**Building Permit Request for 183 Ribbon Oak Court, Sanford, North Carolina 27332**

Revisions to Deck Addition Plans

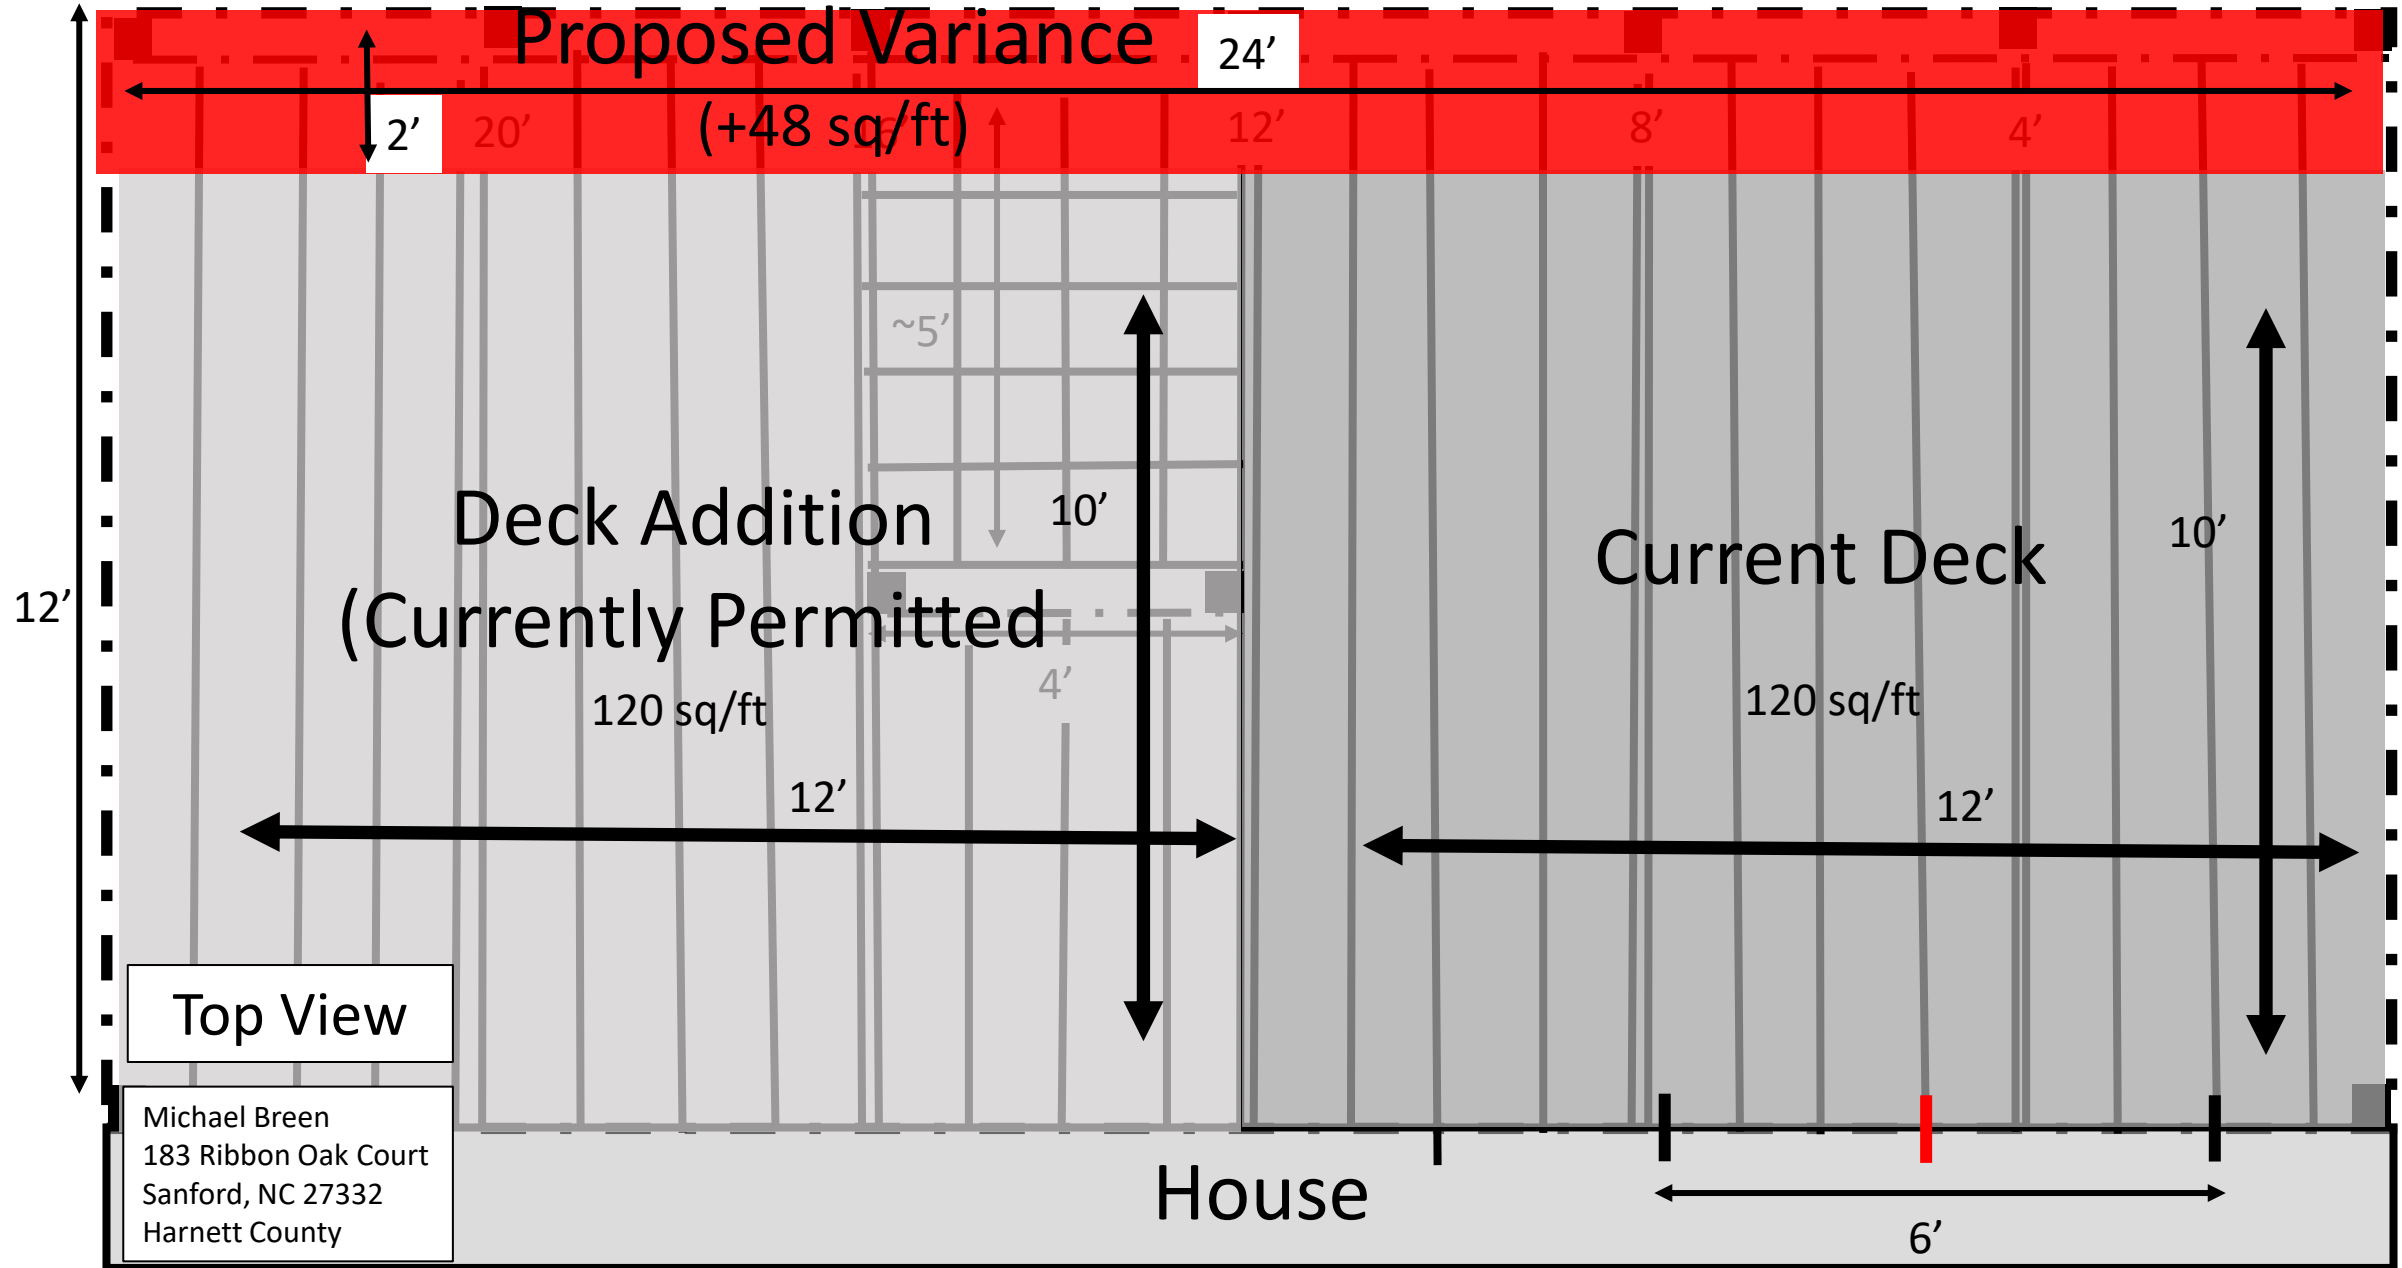
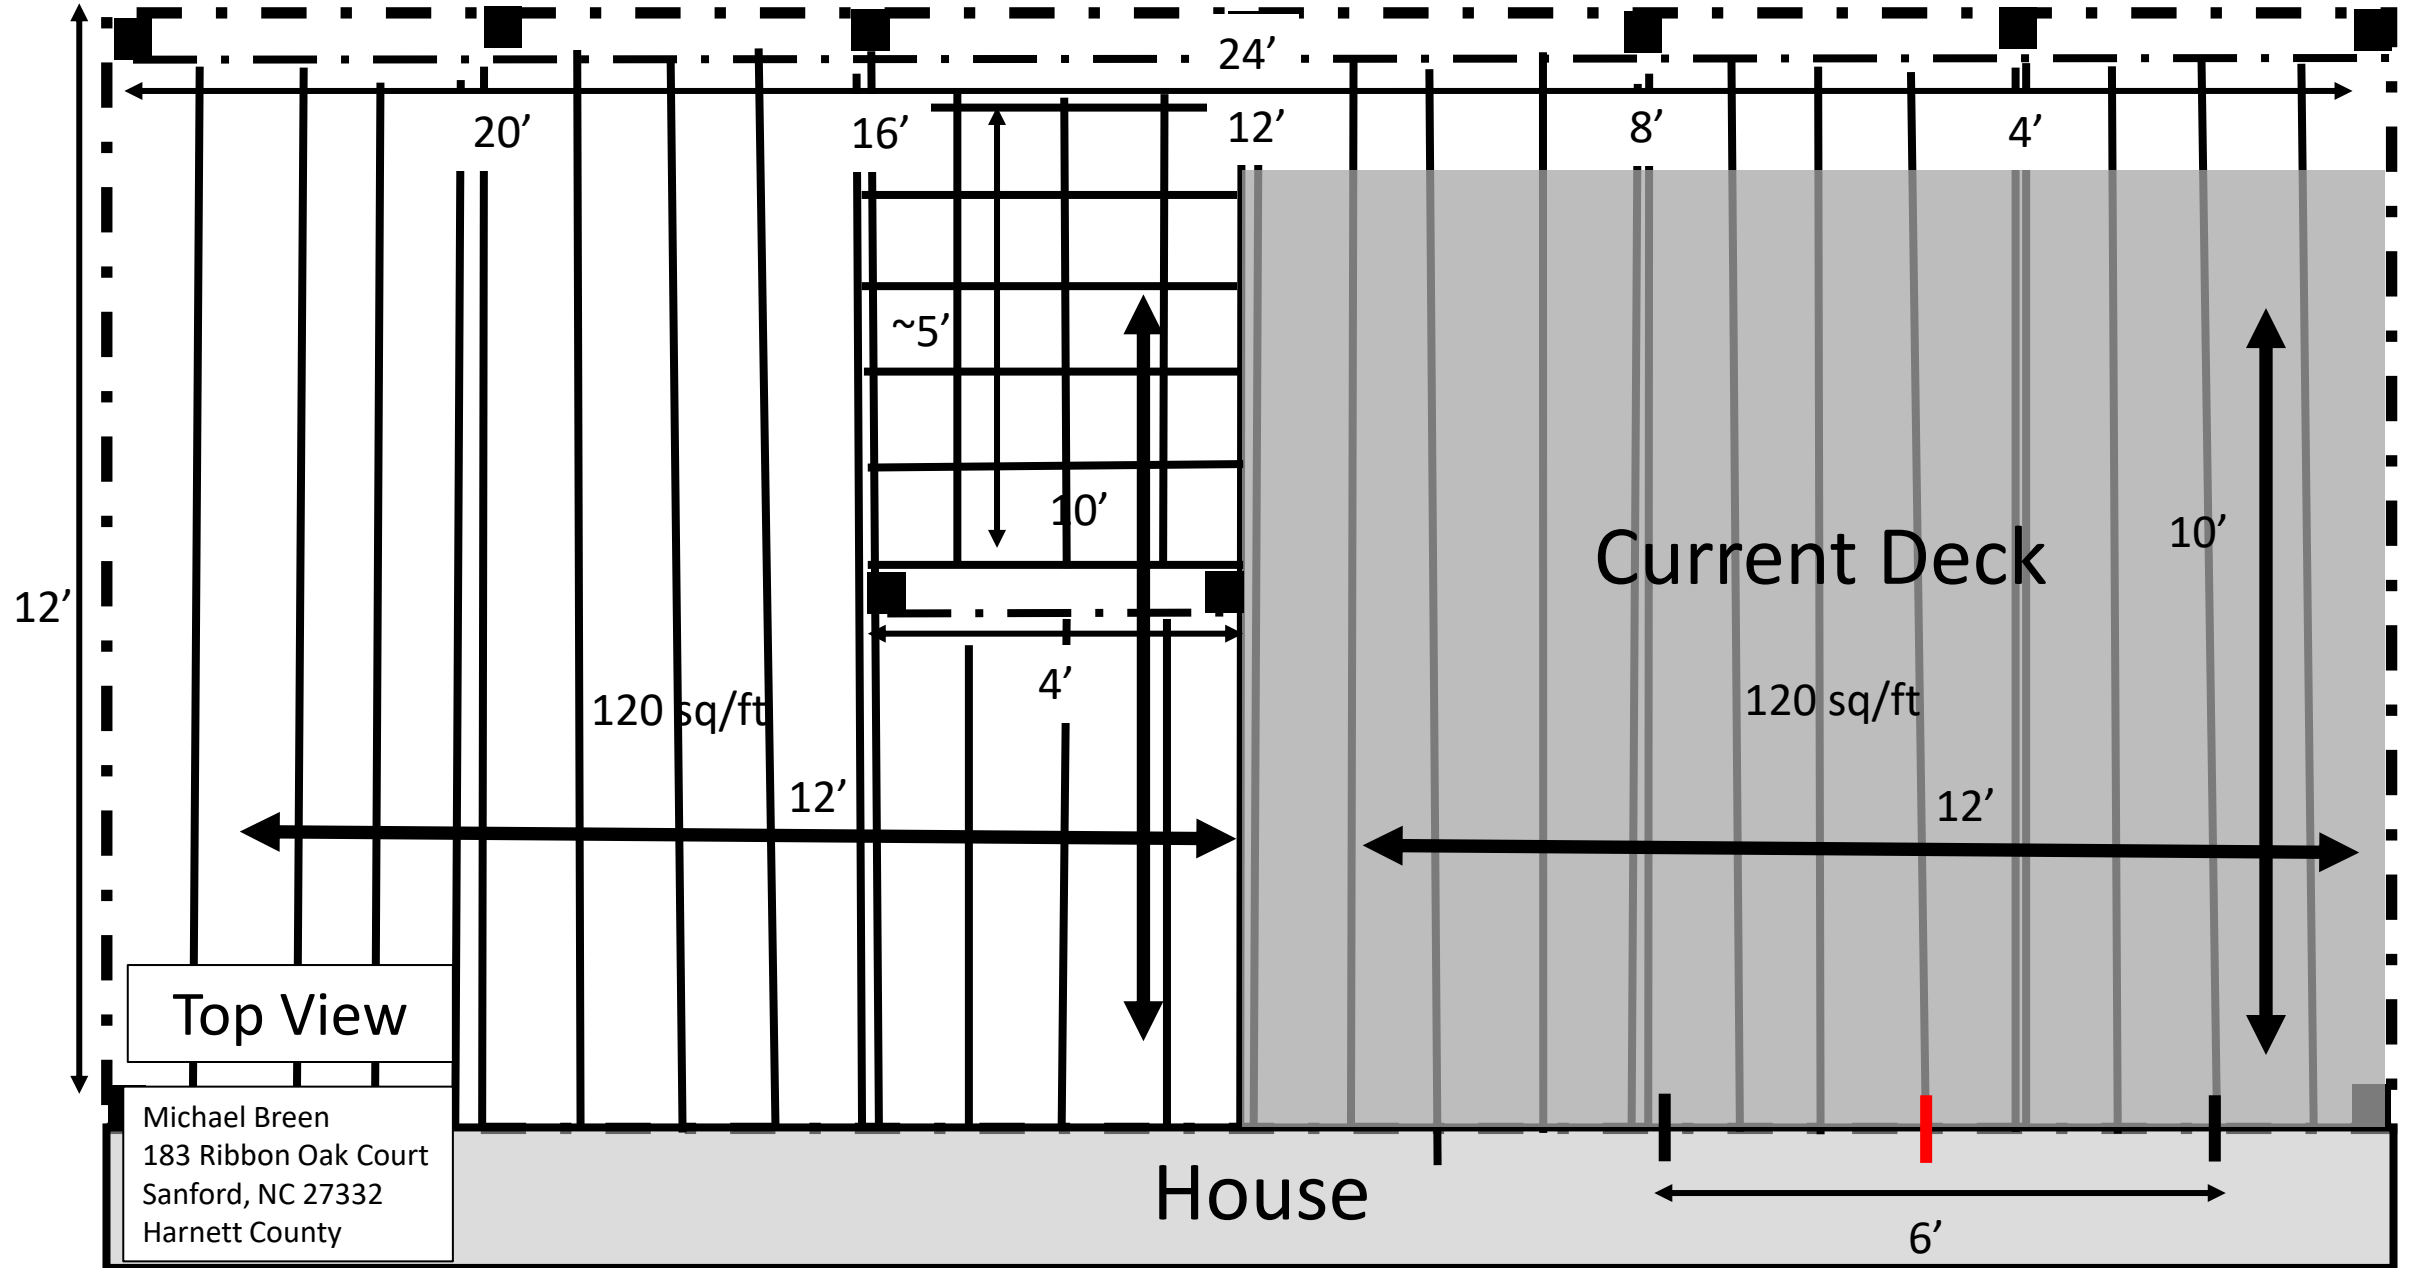
Amendment to Add to Overall Finished Dimension: 2x24' (48 sq/ft).

Planned Overall Finished Dimension: 12x24' (288 sq/ft).

2x8" Joists Changed to 2x10" (12" – O.C.).
